**Phone:** 01772 533487  
**Email:** Laura.makeating@lancashire.gov.uk  
**Ref:** 3/2014/0764  
**Date:** 7 April 2015

**APPLICATION CONSULTATION RESPONSE**

<b>Application Number:</b>	3/2014/0764
<b>Location:</b>	Land East of Chipping Lane, Longridge
<b>Grid Ref:</b>	360084, 437993
<b>Proposal:</b>	[AMENDED PLANS] Outline - Development of up to 520 homes including affordable housing and housing for the elderly, relocation of Longridge Cricket Club to provide a new cricket ground, pavillion, car park and associated facilities, new primary school, vehicular and pedestrian access landscaping and public open space, with all matters reserved except for access.

### **Amended Flood Risk Assessment [REF 880500 R1 (03)]**

Drawing Title: Whole Site Drainage Appraisal Remainder of site

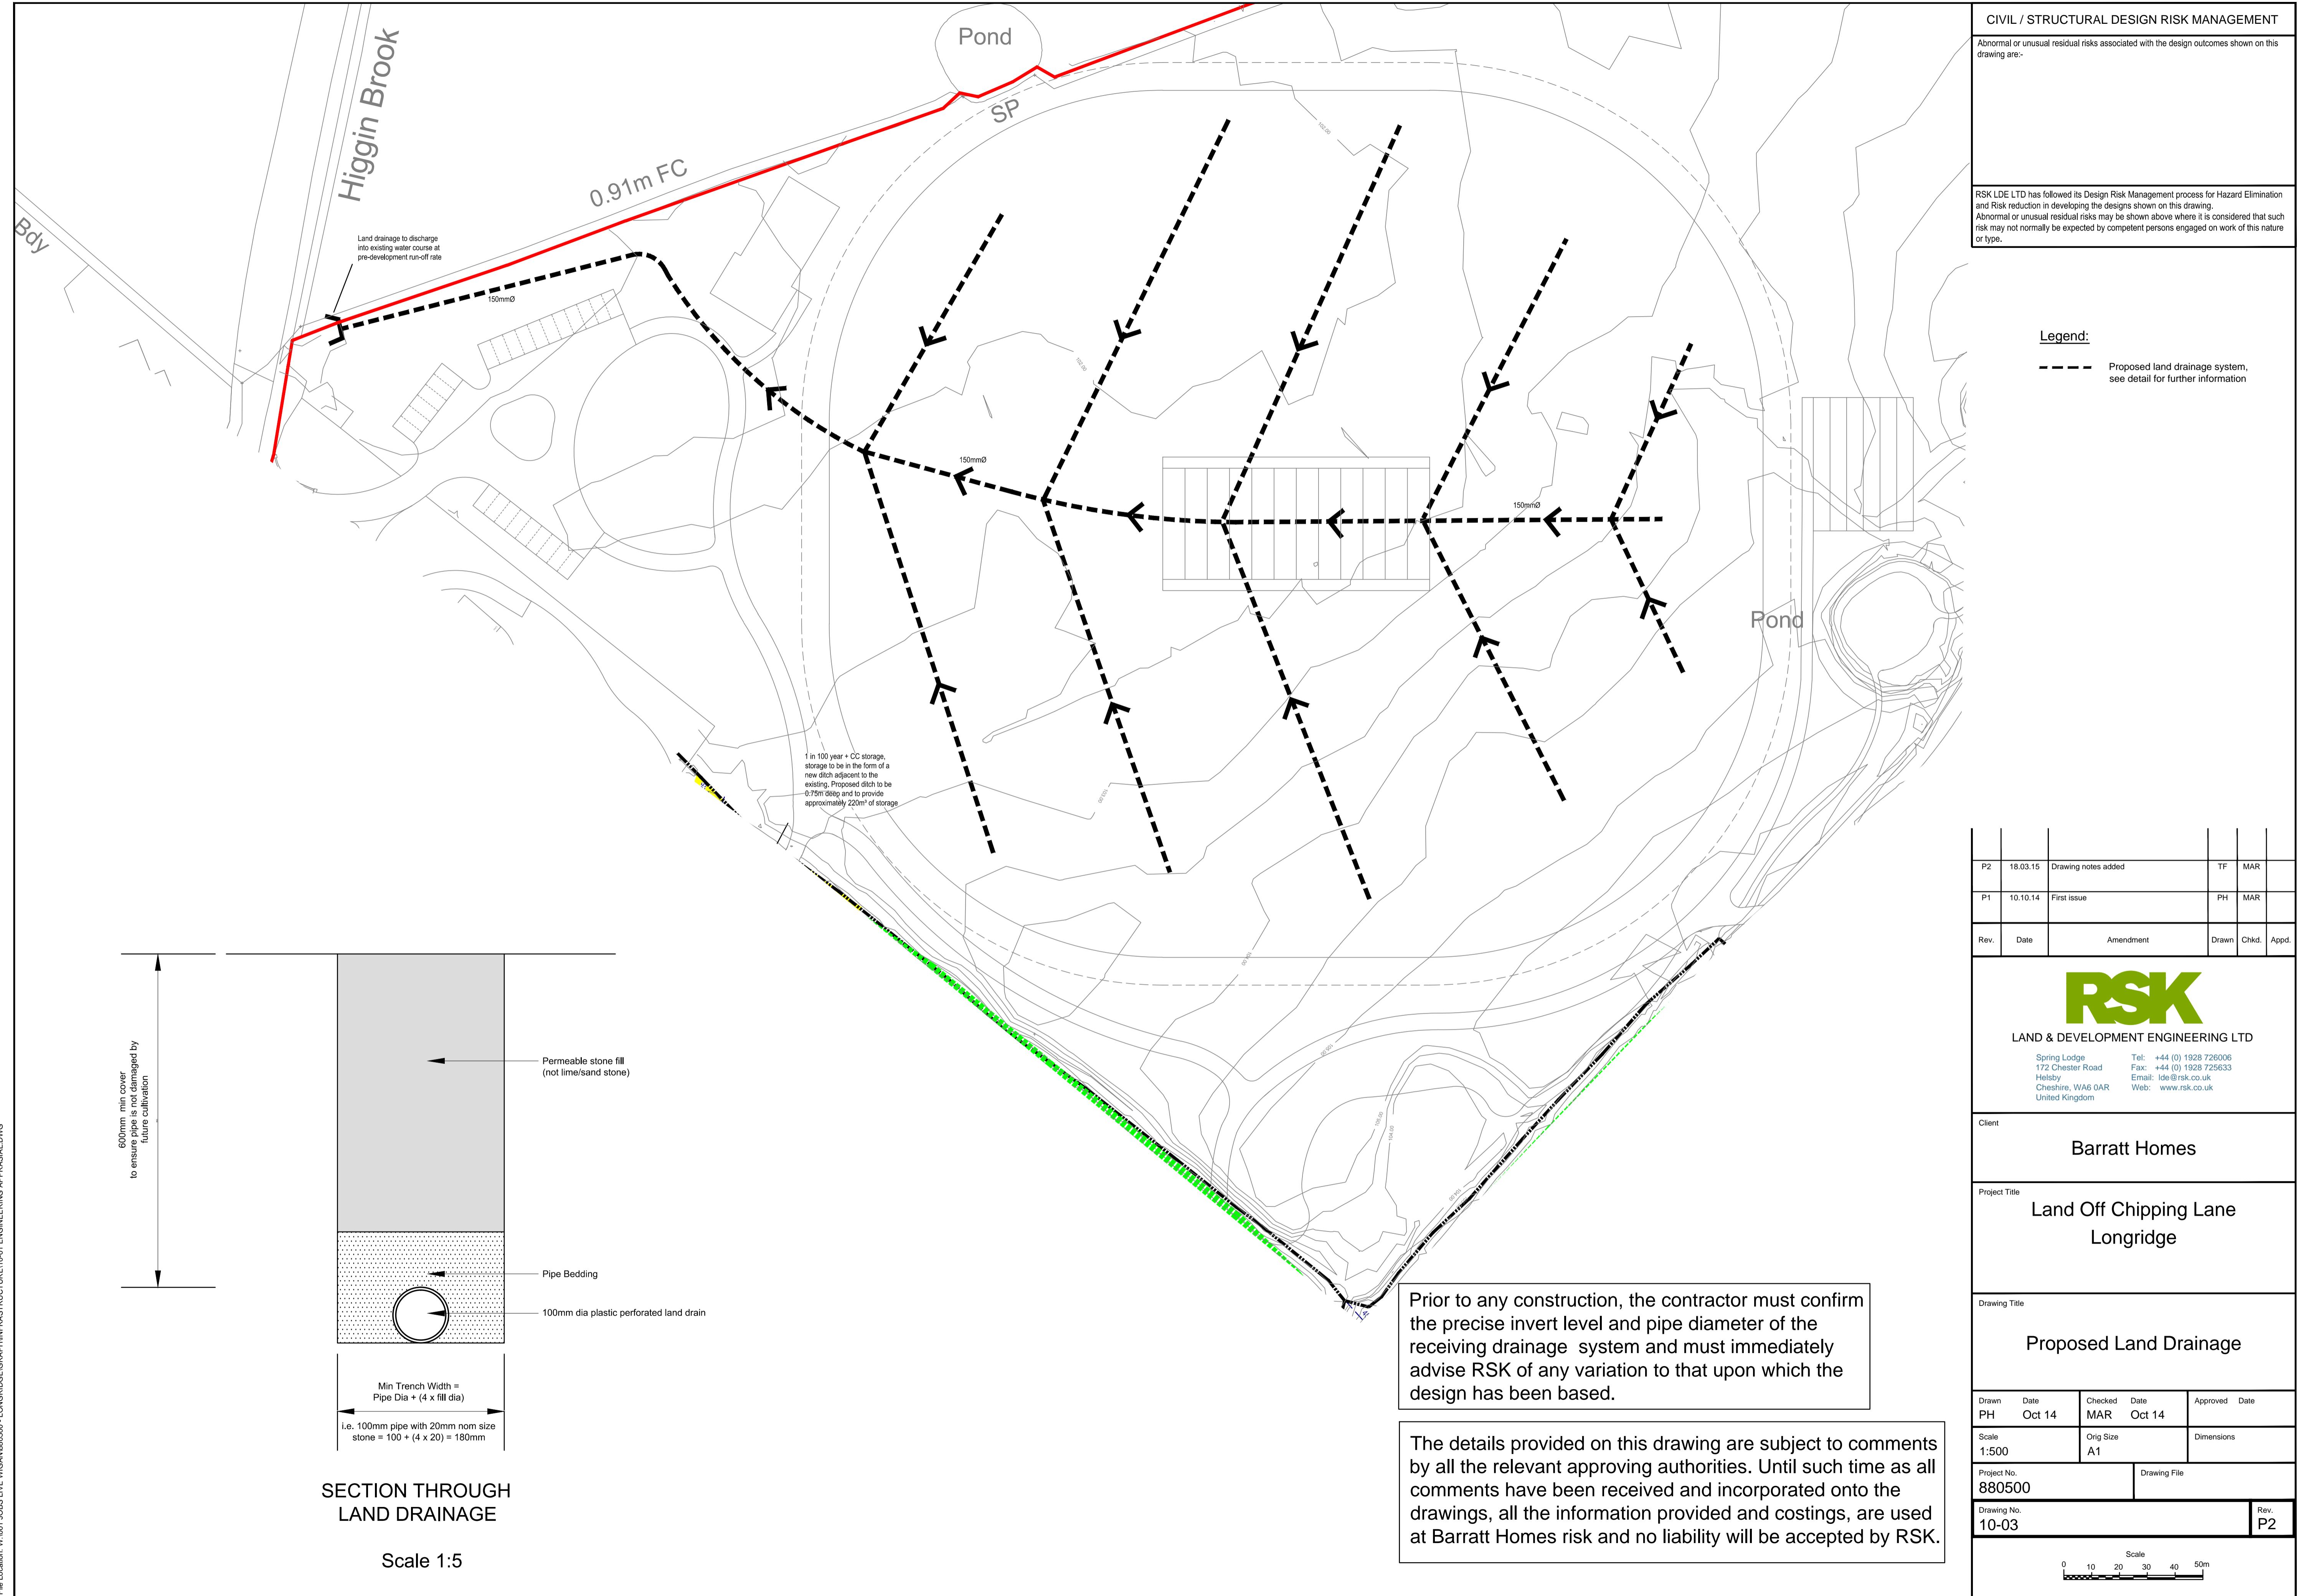
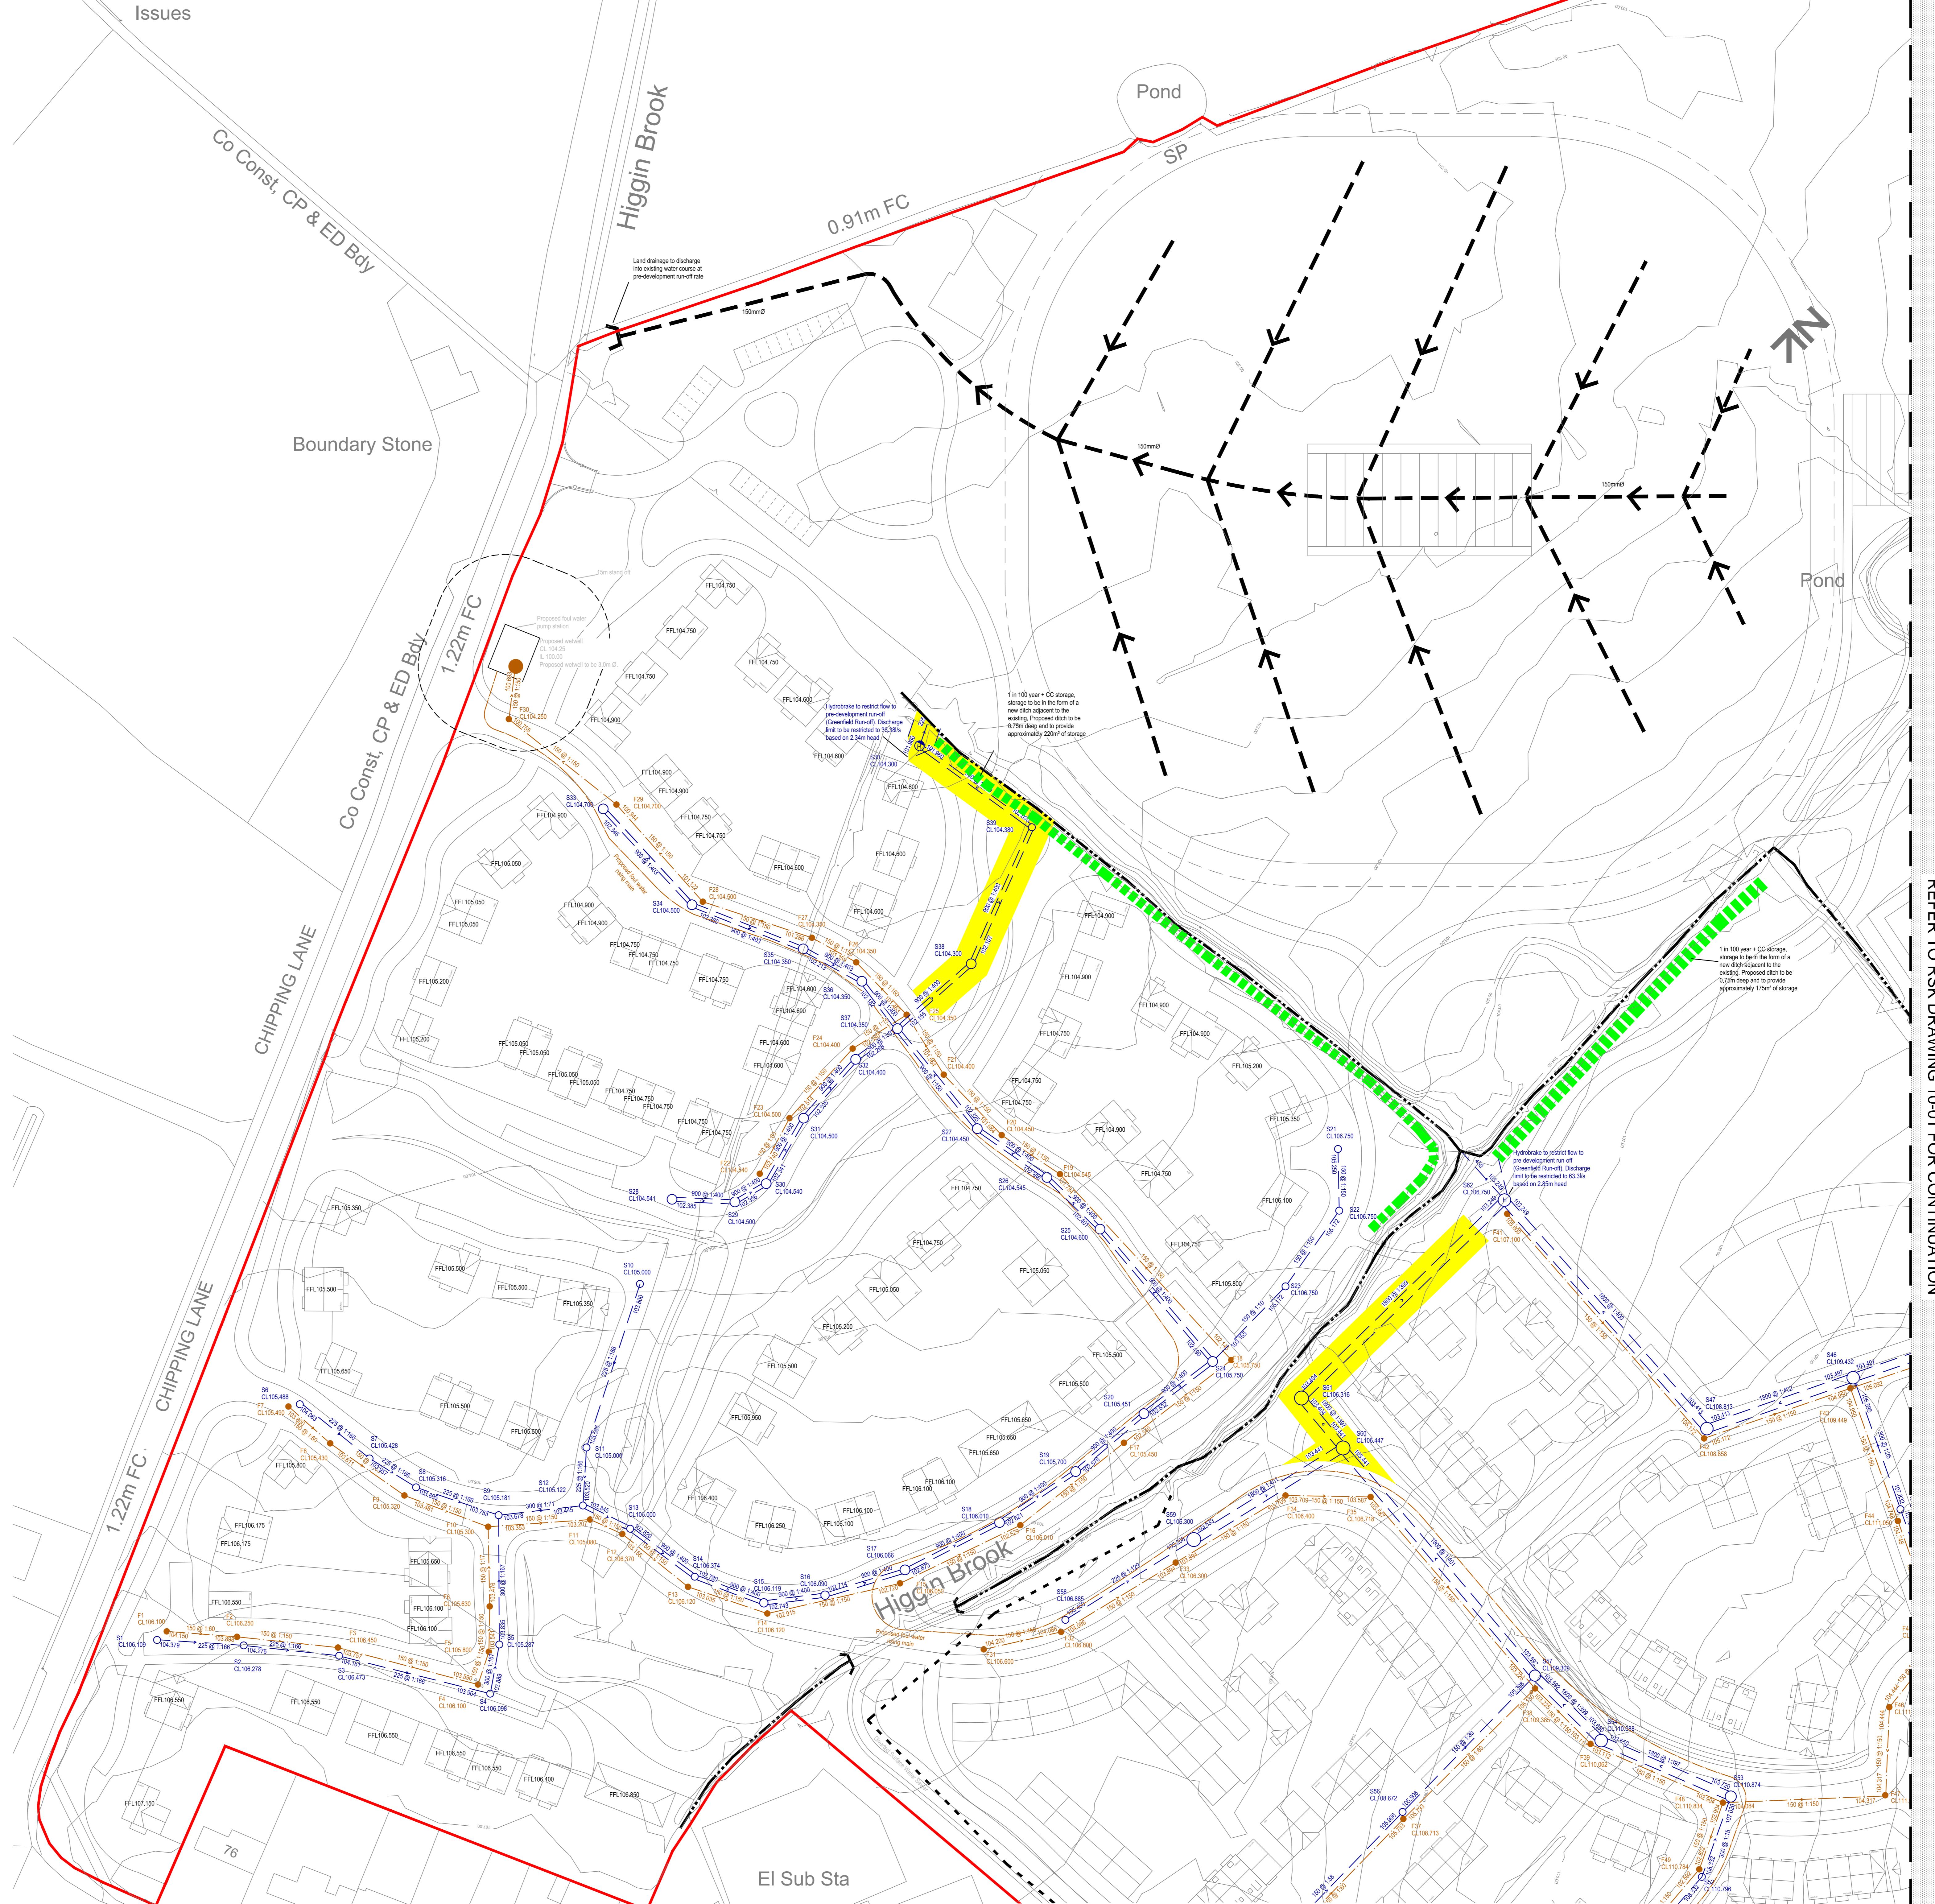
Paragraph 6.1 of the amended FRA indicates that the applicant intends to discharge surface water into Higgin Brook and unnamed watercourses on site at the rate of 7.3 litres per second, which is the QBAR runoff rate. This is intended to be achieved through appropriate use of a sustainable drainage system (SuDS) prioritising the use of infiltration in line with the [hierarchy of drainage options](#) contained within the Planning Practice Guidance. It is advised that Ribbles Valley Borough Council secure the discharge rate at a maximum of 7.4 litres per second (as the QBAR runoff rate) through the use of an appropriate planning condition(s) to achieve this rate to ensure risk of surface water flooding to the proposed development, on-site or elsewhere, is minimised.

It was noted in our previous consultation response that the applicant intends to utilise the existing ponds and depressions within the line of the existing watercourses for the management of surface water. It is unclear from the amended FRA whether the applicant still intends to do so. Should the applicant wish to do so, the applicant must ensure that the ponds are correctly connected to the watercourses so that they function as designed and Land Drainage Consent will be required from the Lead Local Flood Authority. The applicant will also need to carry out a full ecological survey of the ponds and watercourses to determine the presence of any protected species or habitats within the existing ponds and watercourses, and appropriate mitigation measures employed during construction works. In addition to this, written approval from the local planning authority for the final detailed drainage strategy and full planning permission should be obtained before any infilling of ponds is undertaken.

- a) Information about the design storm period and intensity (1 in 30 & 1 in 100 year +30% allowance for climate change), discharge rates and volumes (both pre and post development), temporary storage facilities, means of access for maintenance, the methods employed to delay and control surface water discharged from the site, and the measures taken to prevent flooding and pollution of the receiving groundwater and/or surface waters, including watercourses;
